Subject: A303/Stonehenge PRow - Is a Bridleway missing from the draft DCO and associated Access Plans? (Upfold: 20018352)

To the Planning Inspectorate and Highways England (A303/Stonehenge)

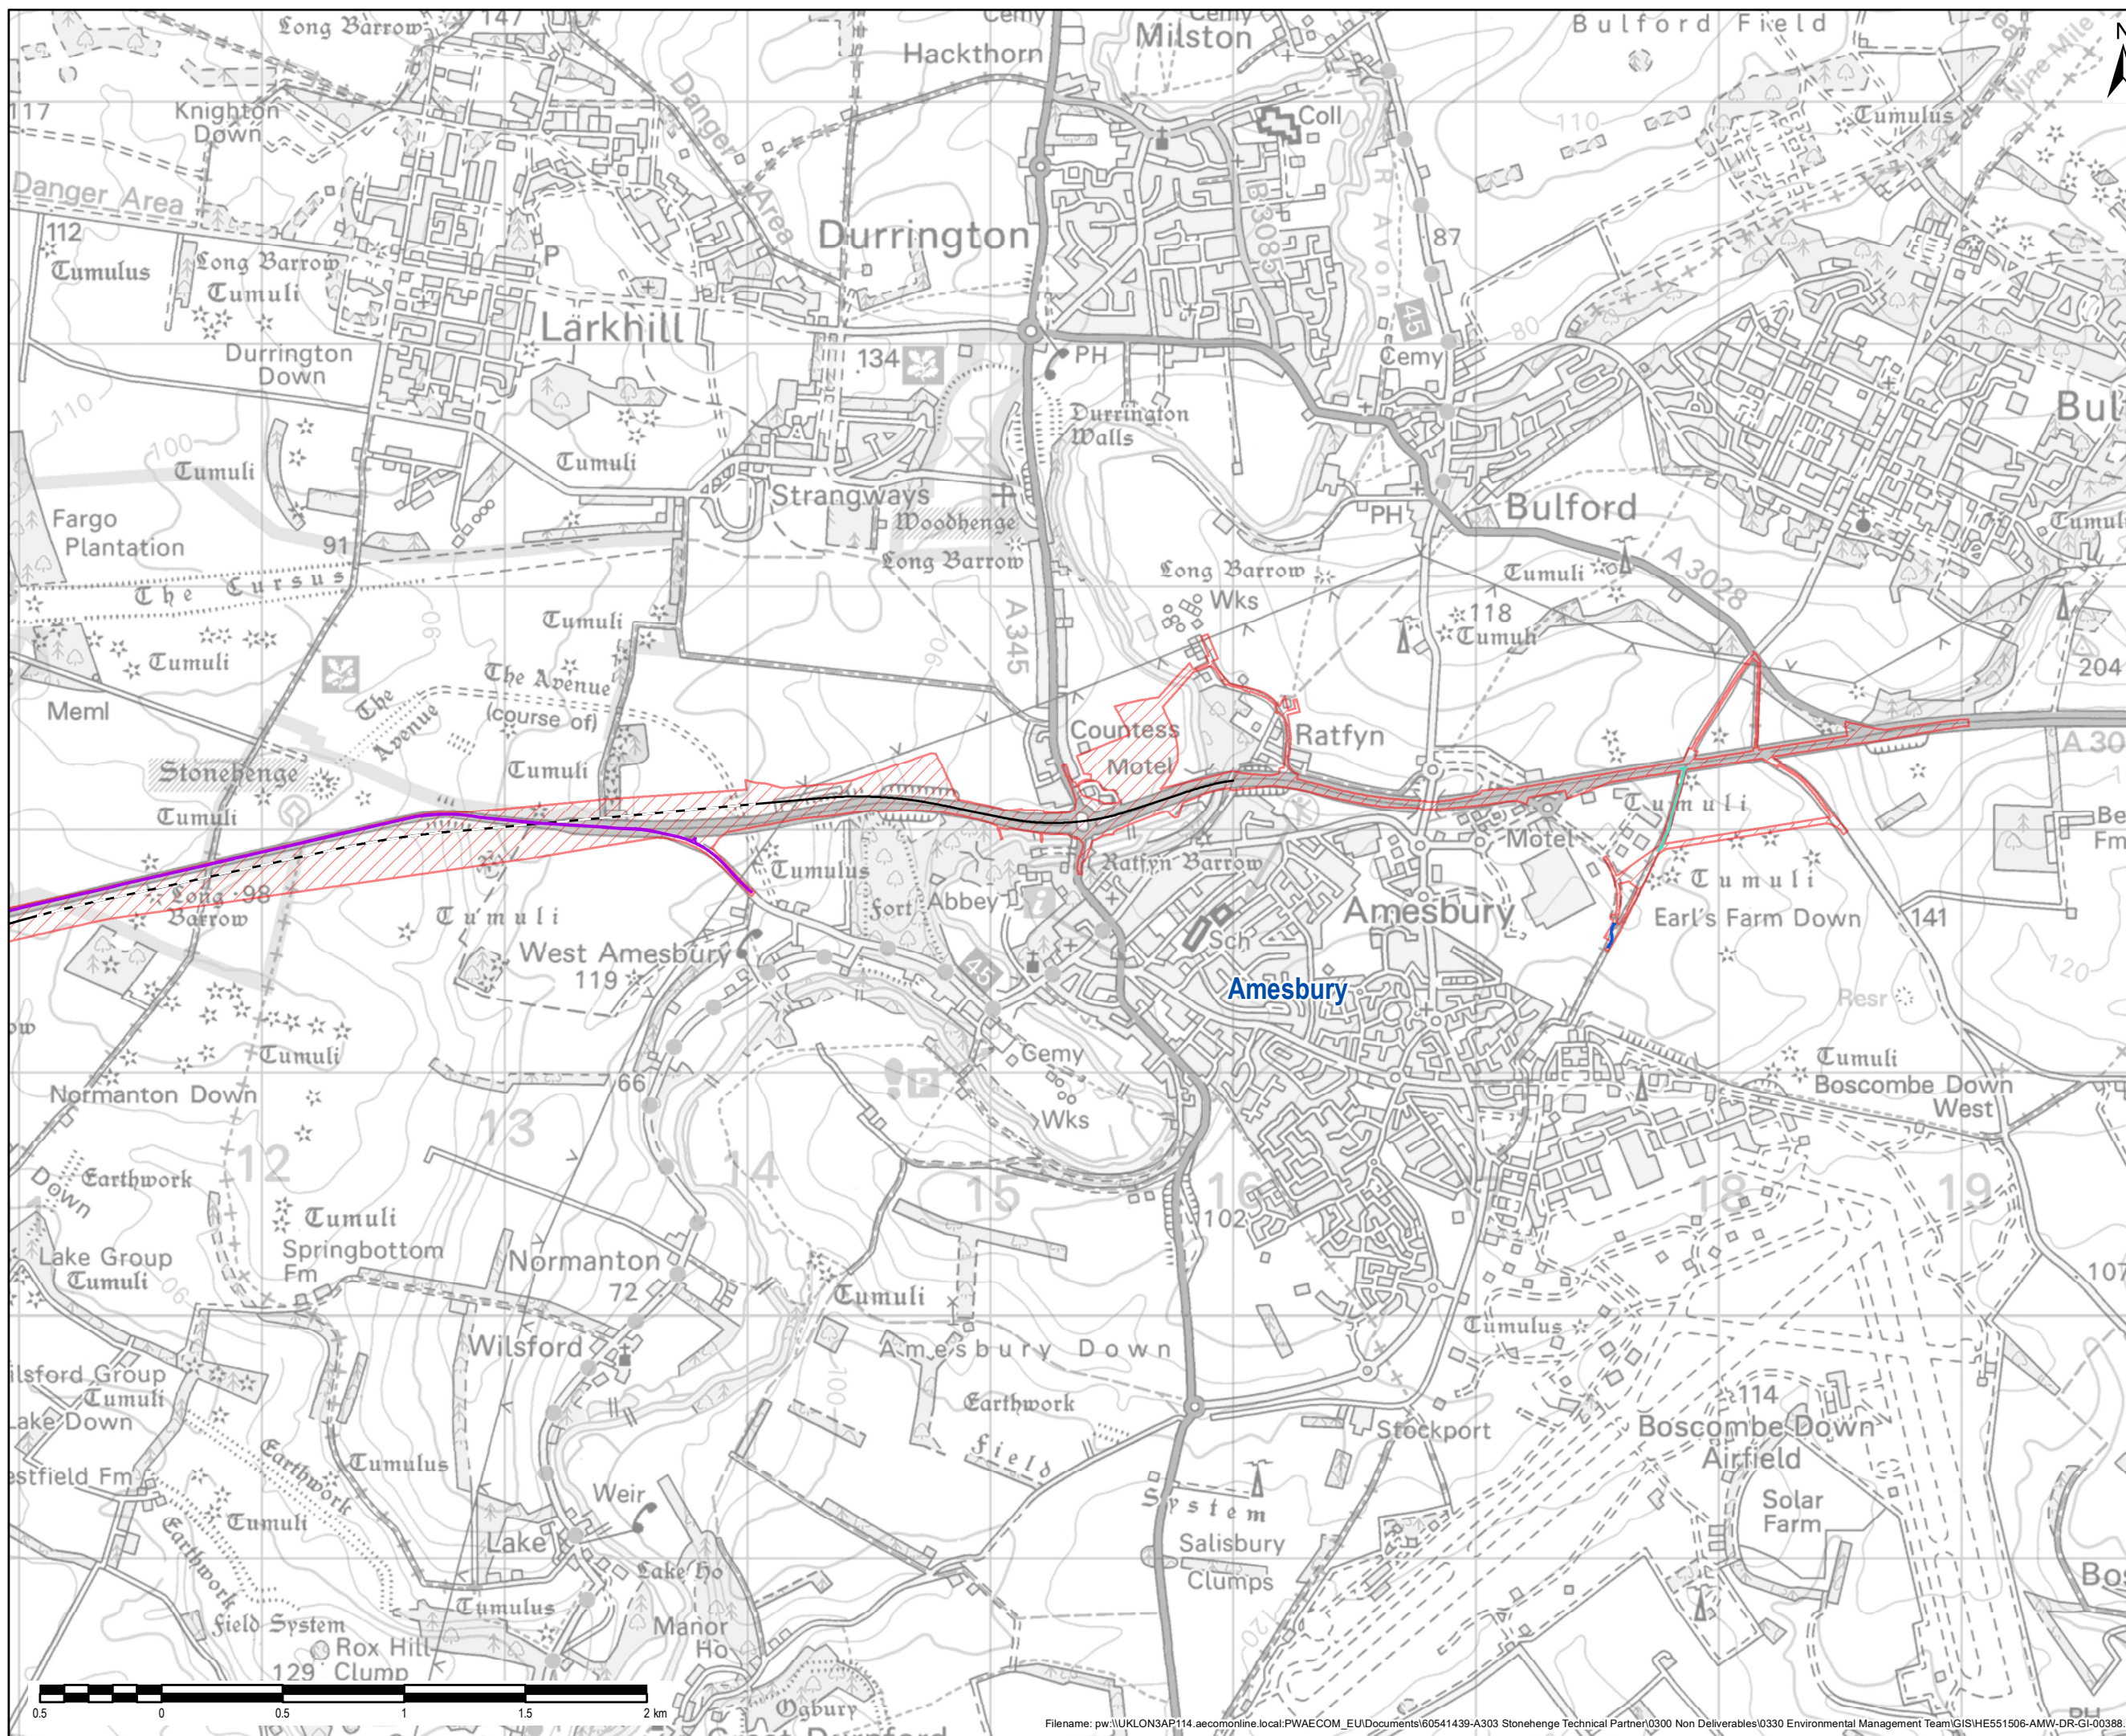
d) a new bridleway, east from Winterbourne Stoke to the new Longbarrow Junction, connecting with the new restricted byway through the WHS via the new green bridge to the east of the existing Longbarrow roundabout. The new bridleway and the new NMU route through the WHS would enable NMU journeys between Winterbourne Stoke and Amesbury;"

which is shown in green in Figure 13.3A of proposed NUM routes (document TR010025-000334-6-2_ES-Figure_13.3_ProposedNMUs.pdf).

From my recollection and notes of the NUM Workshop held by Highways England in Salisbury on 24 July 2018 which I attended, there was some discussion about the positioning of this new 'parallel off-road Bridleway from Winterbourne Stoke to the new Longbarrow Junction, either on the:
